**APPLICATION BY NORFOLK COUNTY COUNCIL FOR GREAT YARMOUTH
THIRD RIVER CROSSING. THE EXAMINING AUTHORITY'S SECOND WRITTEN
QUESTIONS AND REQUESTS FOR INFORMATION**

This response relates to the Examining Authority's further written questions (exQ2) dated 18 December 2019, in relation to the proposed development a river crossing. This letter contains a response to the question directed to the Environment Agency (REF 2.4.1) only.

This representation summarises the review of the revised flood models that were submitted to the Environment Agency and available to view as of 10th December 2019; and the Flood Risk Assessment (FRA) as submitted to the ExA Ref: 6.2- Environmental Statement Appendix 12B which was partially updated by the memorandum referenced GY3RC- Environment Agency Further Sensitivity Flood Modelling (additional review comments) dated 28 November 2019. The additional information submitted does not appear to be available to view on the National Infrastructure Planning Application webpage. Whilst many of the conclusions of the FRA are reasonable and adequately evidenced, there are some areas of concern that remain.

GYTRC-WSP-EGN-XX-DR-EN-2123

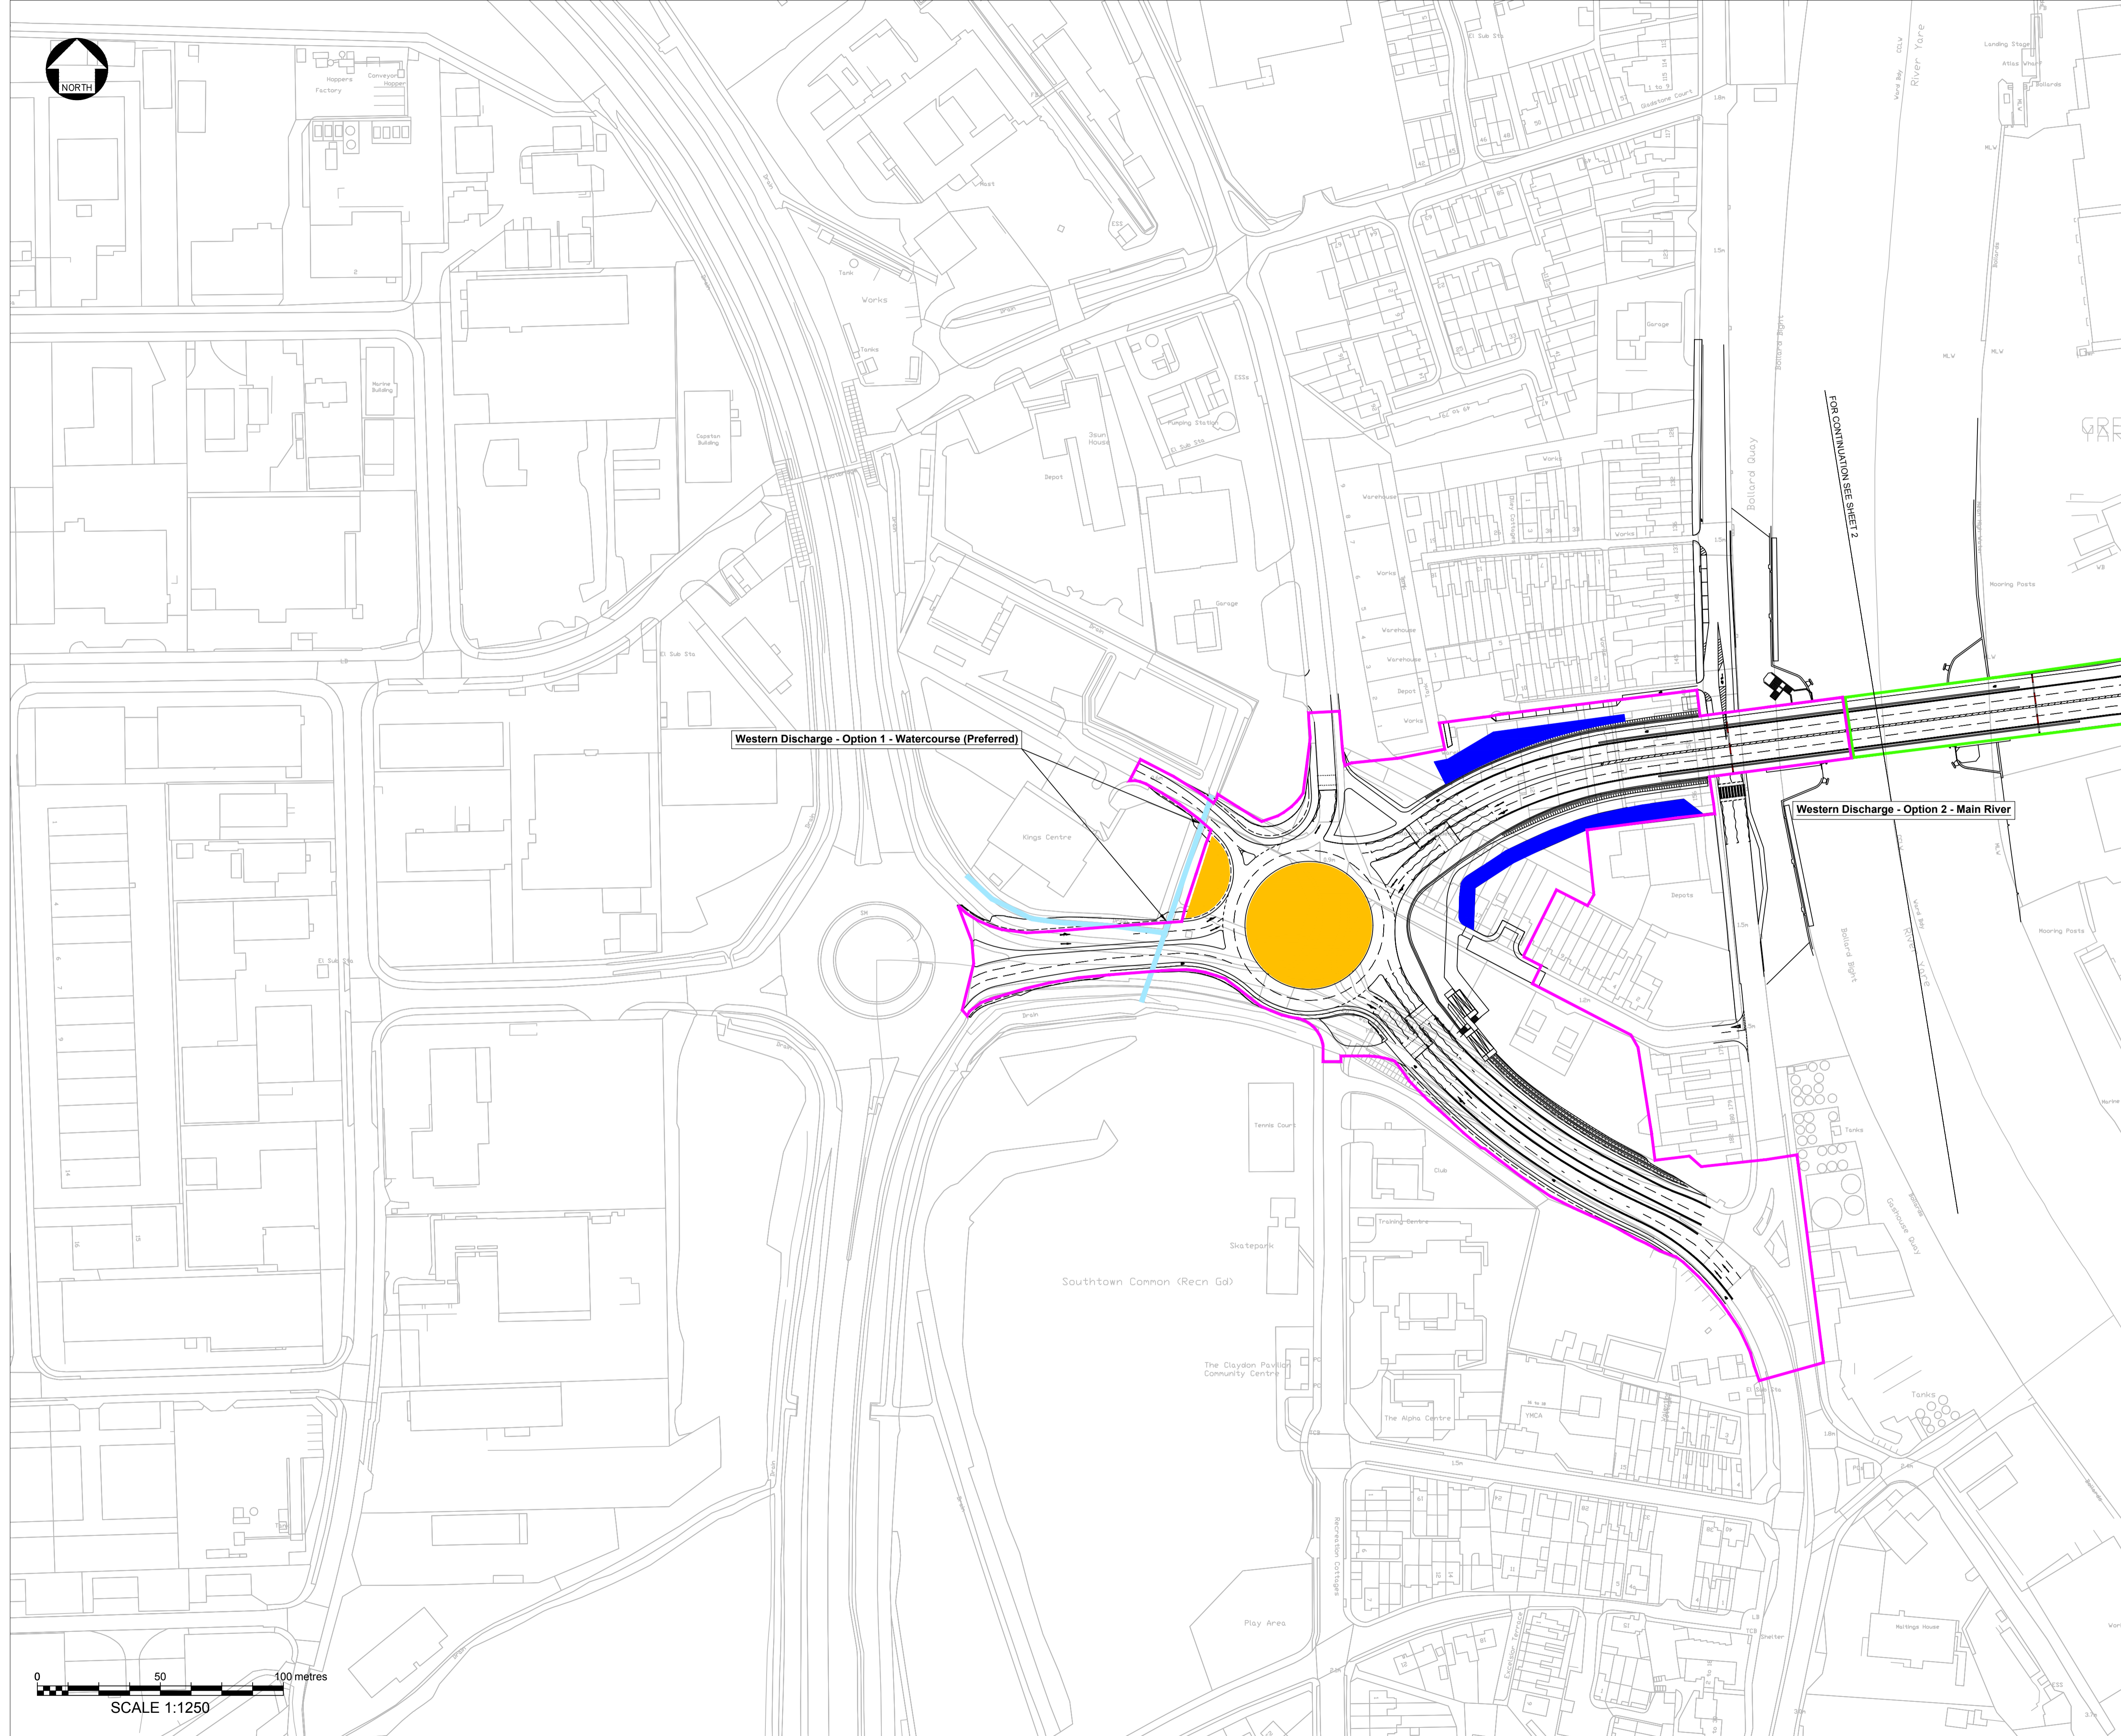
Figure 12B.1 of the Appendix shows the flood risk receptors identified within the assessment study area. We have concerns that this figure appears to be missing a substantial amount of receptors that are relevant to the site. It is likely that a significant number of these missing receptors are dwelling properties. This issue was raised with the Applicant in April 2019. If this figure is showing the receptors that have been used in the FRA, then the Applicant will at least need to account for why significant numbers of receptors in areas close to the scheme are not accounted for and it may be necessary to re-assess those receptors.
